**ADC Planning Consultation
Response from the Historic Buildings Adviser**

Application Number	LU/241/13/L
Address	Toddington House, Toddington Lane, Littlehampton
Description	Application for Listed Building Consent for the demolition of single storey pantry to north elevation and erection of kitchen extension.
Case Officer	Anita Gardner
Site Visit	Previous

DRWG. N° 740/P04-  
SCALE 1:100 AT A3.  
© 26 JULY 2013.

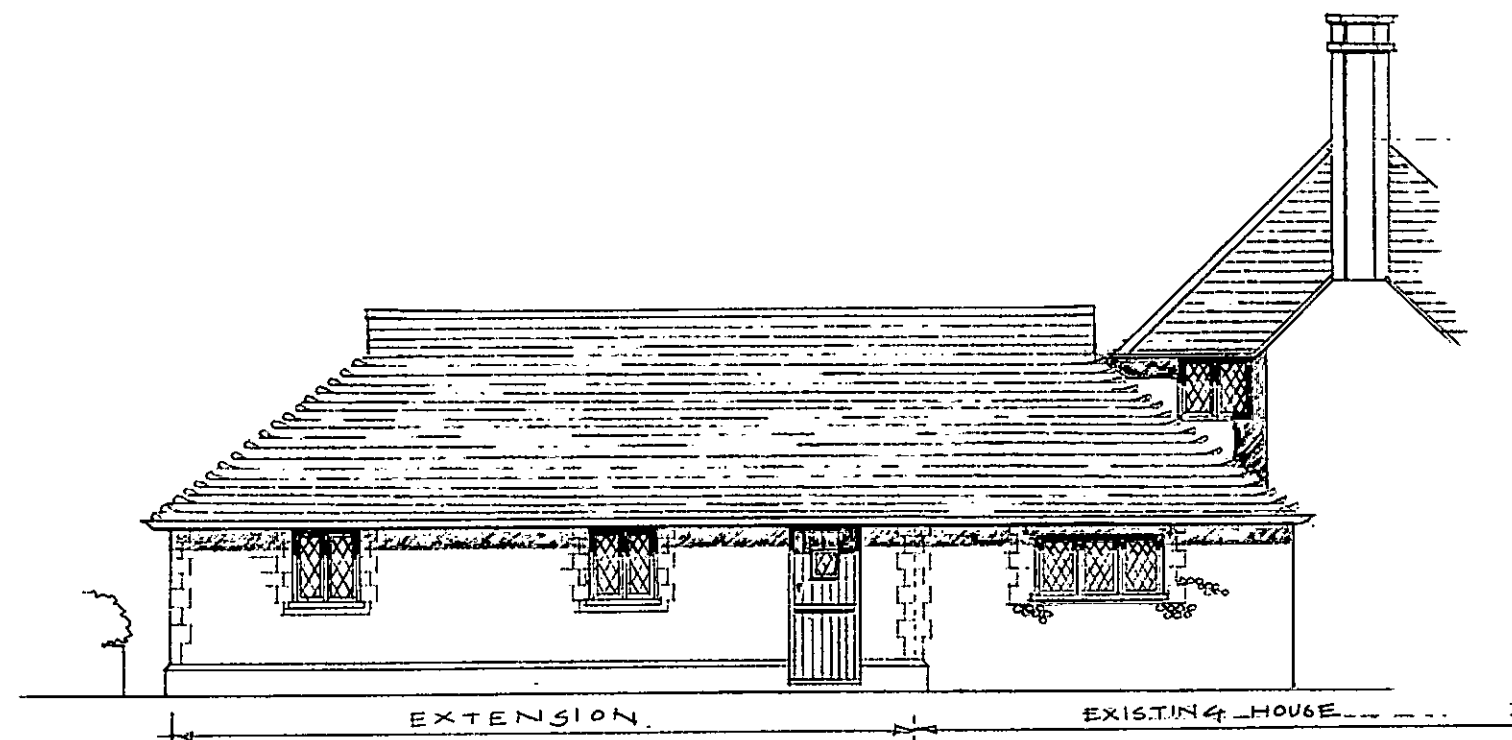
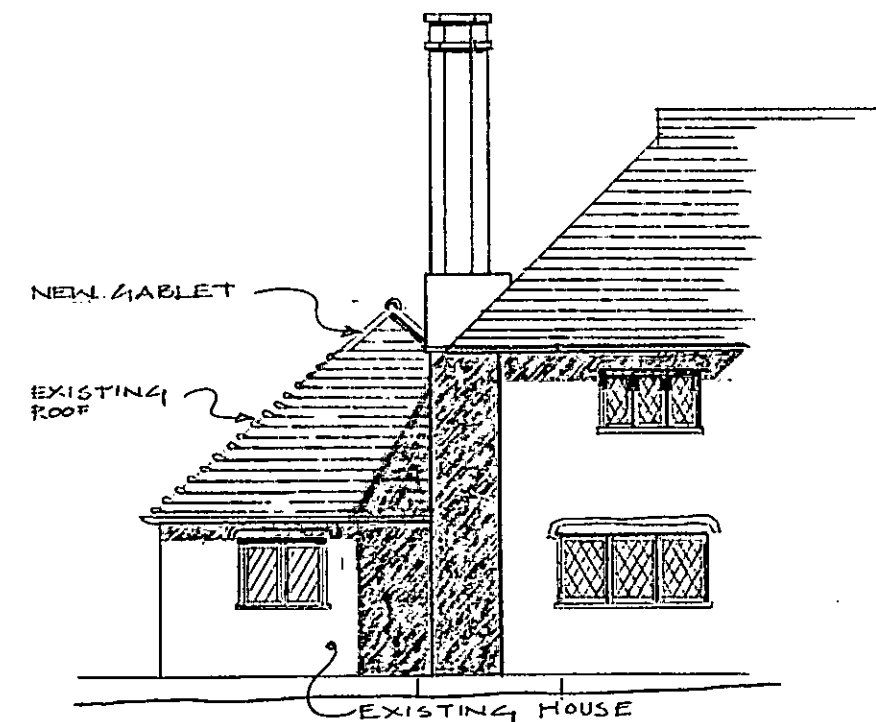
Whilst this scheme is a significant improvement on the previous applications and is acceptable in principle, there remains some concern with the length of the addition. The scale of this has to be justified in terms of the impact on the listed building and as viewed both on plan and in elevation, would seem to be considerable.

Given the space that is being released within the existing building, it would seem more reasonable that the utility should be maintained within the existing envelope – in either the ‘ex-kitchen’ or ‘ex-library’. This would reduce the need for such a long extension which in turn would mitigate its impact on both the front elevation and side elevation as viewed from within the garden. If this can be achieved, full support is likely to be forthcoming.
